Please ask for: Ms Iqraa Malik
Email: iqraa.malik@terraquest.co.uk
Telephone: 01212341390
Our Ref: WA/38/21/HH
Your Ref:
Date: 7th May 2021

Application for Planning Permission for Works or Extension to a Dwelling

Development: Erection of rear extension. (This application may affect the character and appearance of the Walberton Village Conservation Area)
Location: 1 Orchard Terrace The Street Walberton BN18 0PH

BLOCK PLAN 1:200

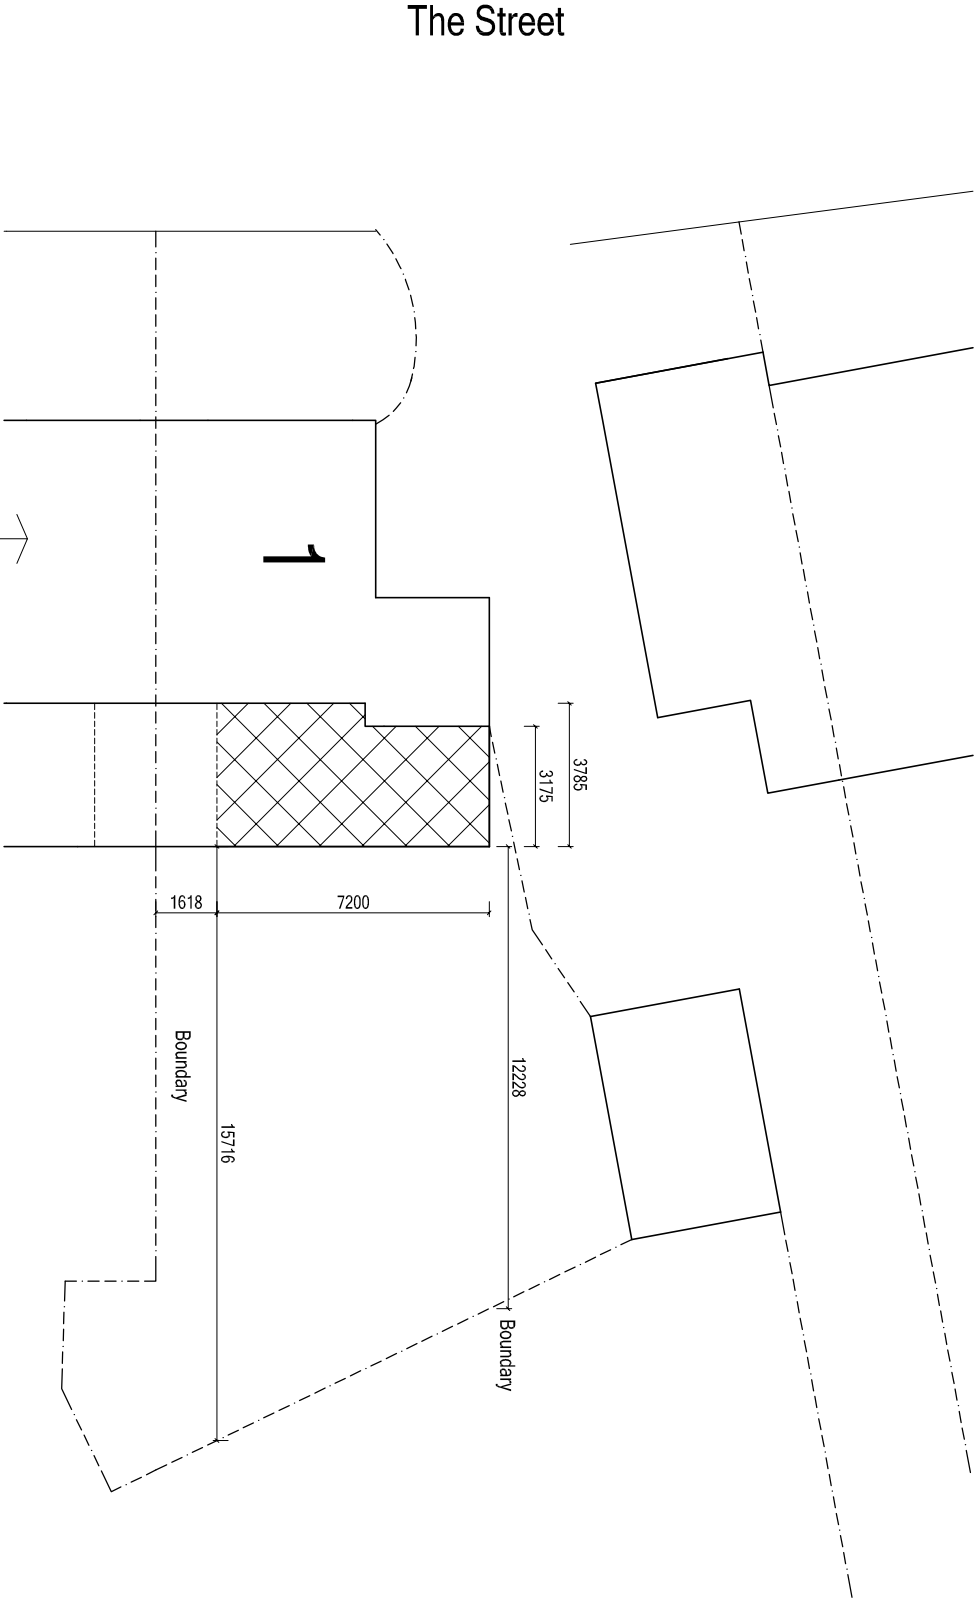
Block Plan

You are required to have dimensions from the proposed extension(s) to all site boundaries. Please amend.
